**RE: 130 Eastern Promenade  
Level II - Amendment to Site Plan  
City Project ID: 2014-050  
CBL: 003 C001001**

On behalf of 130 Eastern Promenade, LLC, Carroll Associates is pleased to submit this Site Plan Amendment for your review and approval. The most recent approval was an Administrative Authorization approval by you, dated 11/12/2014. Since then construction has been underway and things are just about complete. Recently Phil DiPierro was on site to do a Site Plan Compliance Inspection in an effort to have the Certificate of Occupancy issued and he identified a number of site related items that were different from the approved plans or incomplete which need to be reviewed/documentated before he can sign off. Below is a list of his comments (*in italics*) and the applicant's responses (**in bold**). Changes to the plan set have been identified with a revision cloud.

Drawing file: Revised Site Plans / L-2.0 Site Layout & Materials Plan_original.pdf

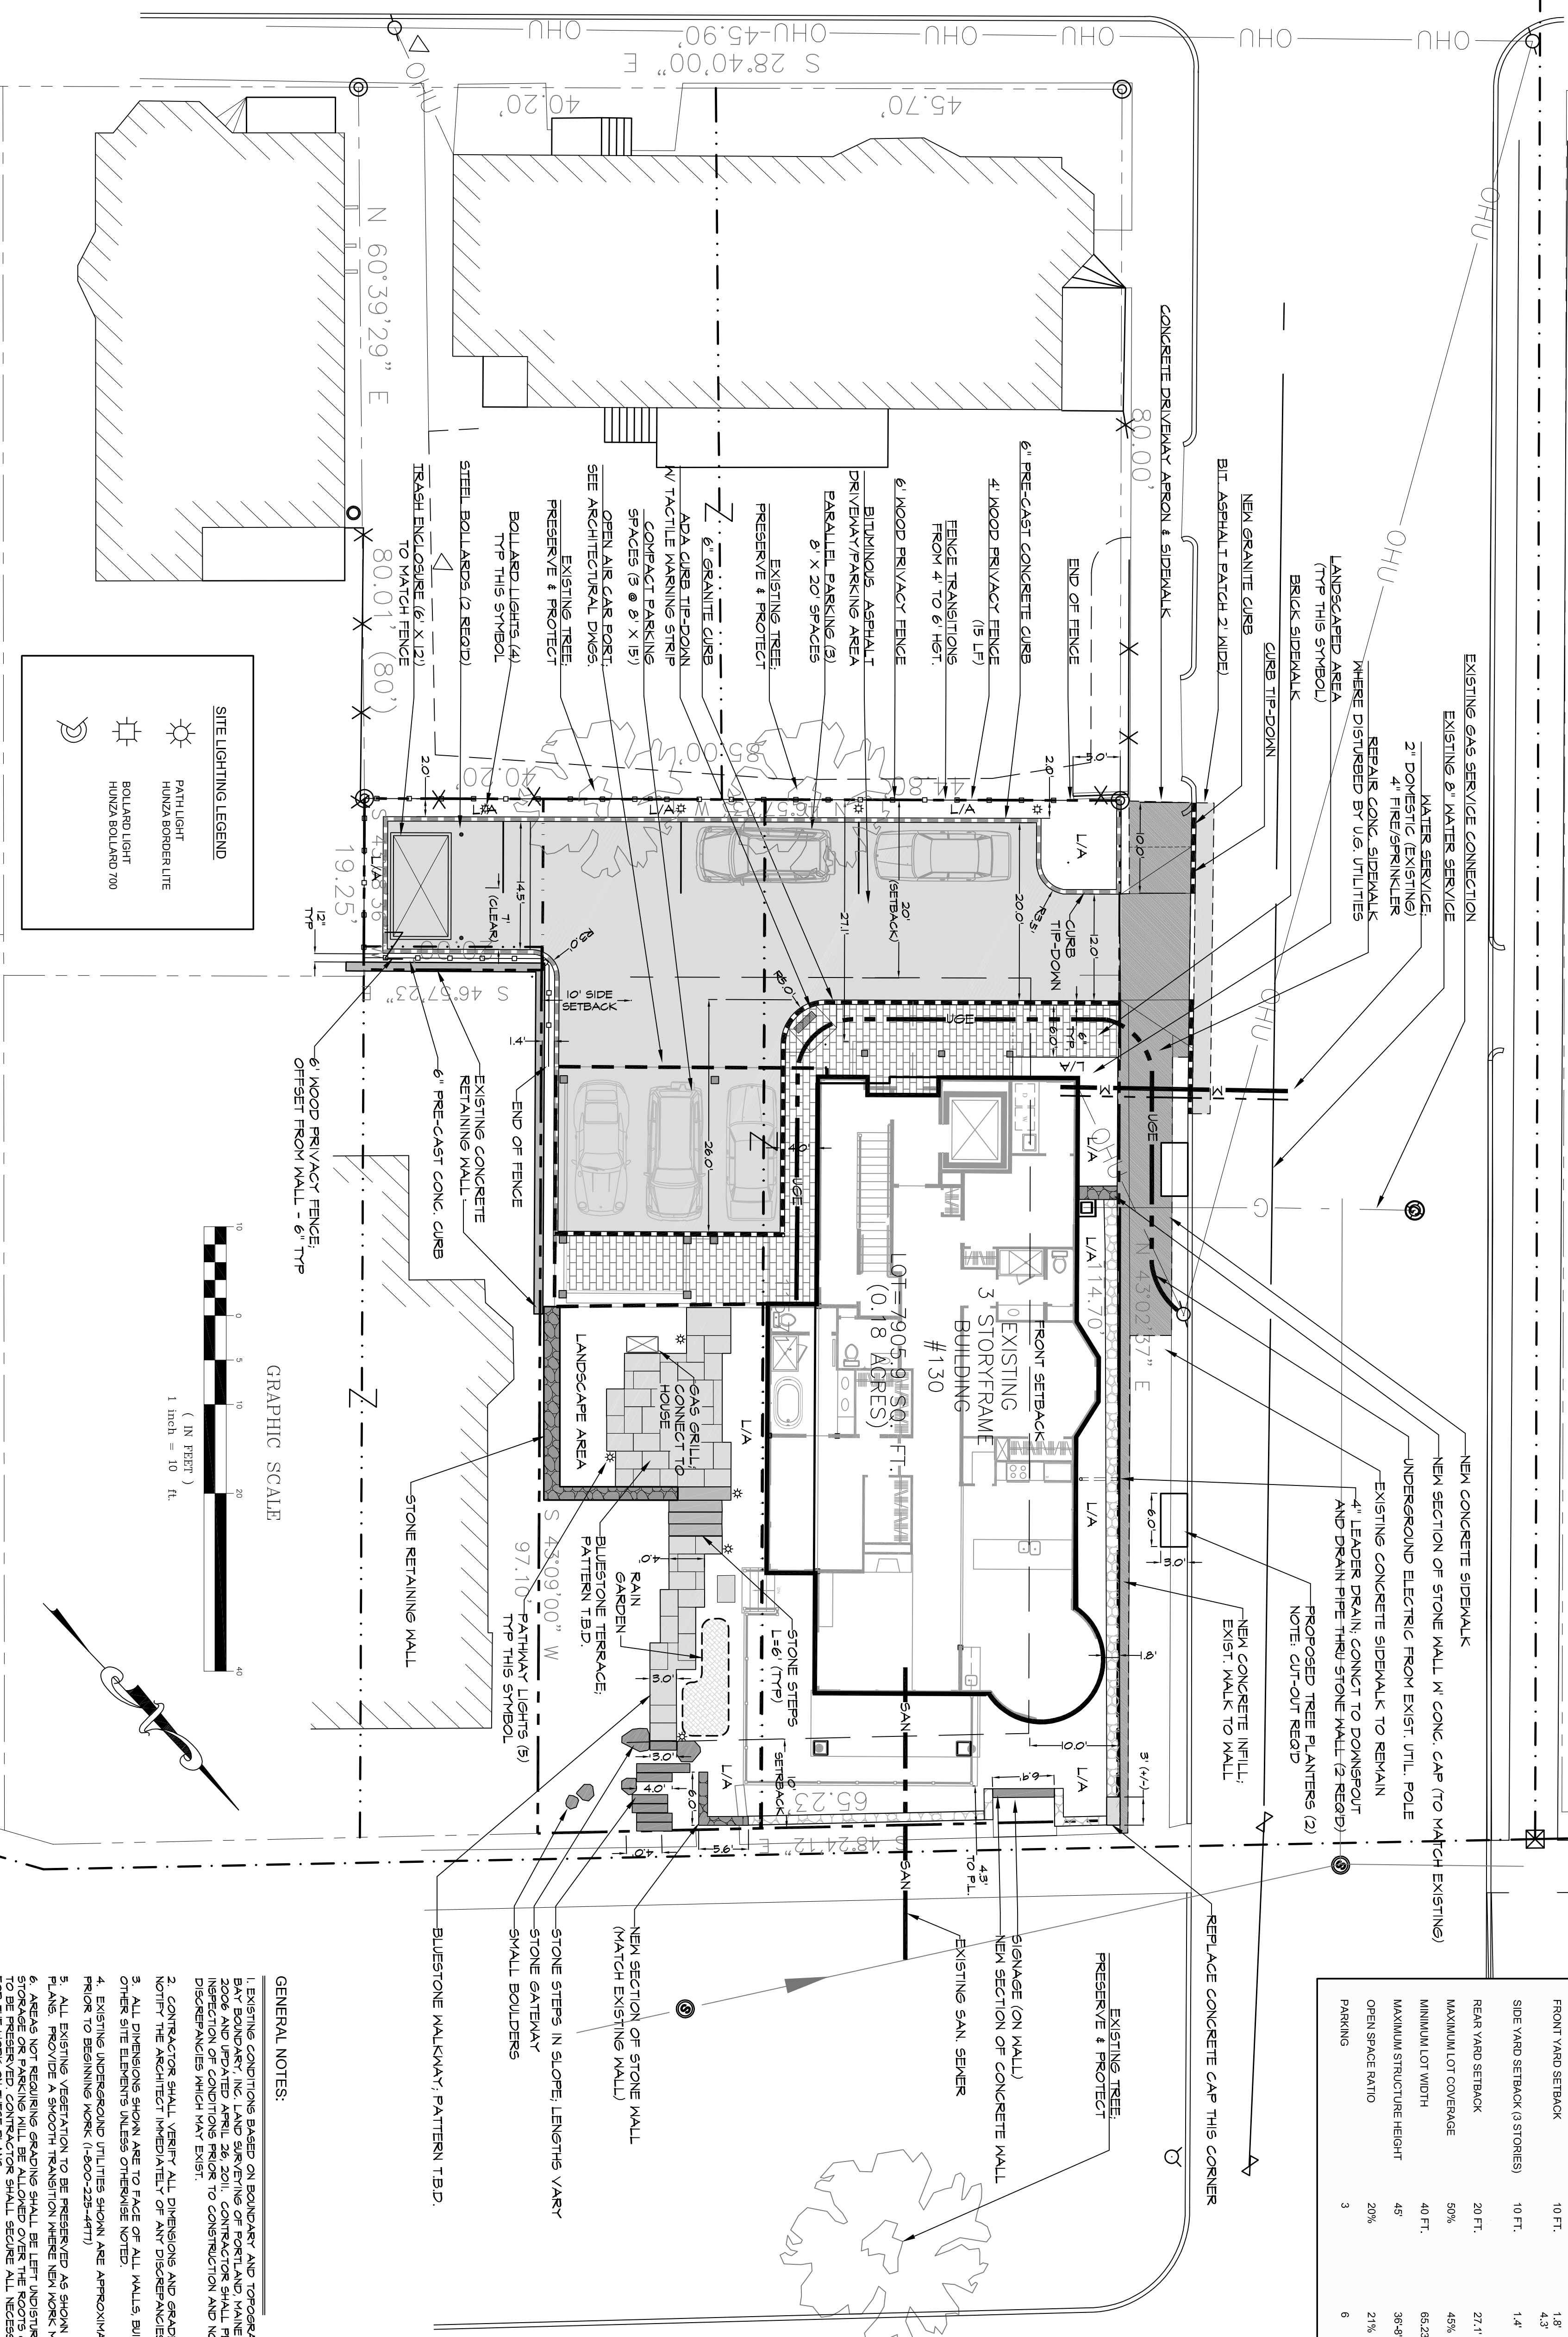
- 1. the concrete curb in the parking lot was not installed according to the approved site plan.*  
**Response: The curb and slope along the western property line was eliminated and replaced with a small retaining wall instead. The mutual decision to build the small retaining wall was made in conjunction with the neighbor to the west. As previously approved (and a condition that had been occurring for decades) the runoff from the adjacent/upper parking area was sheet flowing onto the subject property and adding a lot of unwanted stormwater and debris to the applicant's parking lot. This condition was not known at the time of approval as there was an existing garage/barn structure backed up to the property line in this location. In an effort to mitigate the situation, while also improving ease of vehicular access/maneuvering, ease of maintenance, and overall aesthetics; a small wall was proposed to be built. This eliminates the slope and keeps runoff from sheeting across the property line.**

- 2. the 4 foot high wood privacy fence was not installed according to the approved site plan.*  
**Response: During construction a decision between the applicant and the adjacent neighbors was made that the fences were not necessary and actually not desired. By eliminating the fences it allows for more sunlight into the area (which will help with melting in winter months), provides a more open feeling, and eliminates snow plowing, parking, and associated maintenance issues. The applicant has worked with the westerly abutter and installed wheel stop in the adjacent parking lot to keep cars properly parked.**

4. *the bollard lights and path lights have not been installed according to the approved site plan.*

5. *the bike hitch has not yet been installed.*

8. *the walkway leading from the sidewalk to the parking lot was not installed flush according to the approved site plan.*

11. *the retaining wall that was constructed on the west side of the parking lot was never approved on the site plan.*

**Response:** At the rear of the building, the four bollard site lights were removed because of the lack of room between the retaining wall and driveway. The rear of the subject building will have three building mounted lights. It was felt that between these three, all the other adjacent property lights, and the street light on Wilson Street there was sufficient light for the rear of the project without impacting abutter further.

At the front of the building we are proposing two small path/down lights on each side of the two front stairs. The previous plan only called for a total of two (one at each stair) but the applicant would like to located one on each side of the steps for safety. Small residential porch lights will be located at the porch doors.

**Response:** The location of the bike racks has been relocated to either side of the main rear door, parallel to the building, along the sidewalk. We are now proposing two bike hitches; each located close to the building and accommodating only one bike. They will be located approximately 18" off the building to accommodate one bike per rack, to allow for clearance along the sidewalk. It will be completed in the near future.

**Response:** The sidewalk between the parking lot and the building was not built flush as shown on the approved plans but instead was modified to provide a 4" curb for protection against runoff entering the building. The parking lot was slightly re-graded to accommodate this change. The 4" curb will provide some freeboard for the ground/lower lever units from flooding should the parking area ever back up due to ice damns at the street or other unforeseen events. The curb also provides an additional level of safety to pedestrians on the sidewalk and the building from vehicles maneuvering in the driveway.

**Response:** As previously noted, the curb and slope along the western property line was eliminated and replaced with a small retaining wall instead. The mutual decision to build the small retaining wall was made in conjunction with the neighbor to the west. As previously approved (and a condition that had been occurring for decades) the runoff from the adjacent/upper parking area was sheet flowing onto the subject property and adding a lot of unwanted stormwater and debris to the applicant's parking lot. This condition was not known at the time of approval as there was an existing garage/barn structure backed up to the property line in this location. In an effort to mitigate the situation, while also improving ease of vehicular access/maneuvering, ease of maintenance, and overall aesthetics; a small wall was proposed to be built. This eliminates the slope and keeps runoff from sheeting across the property line.
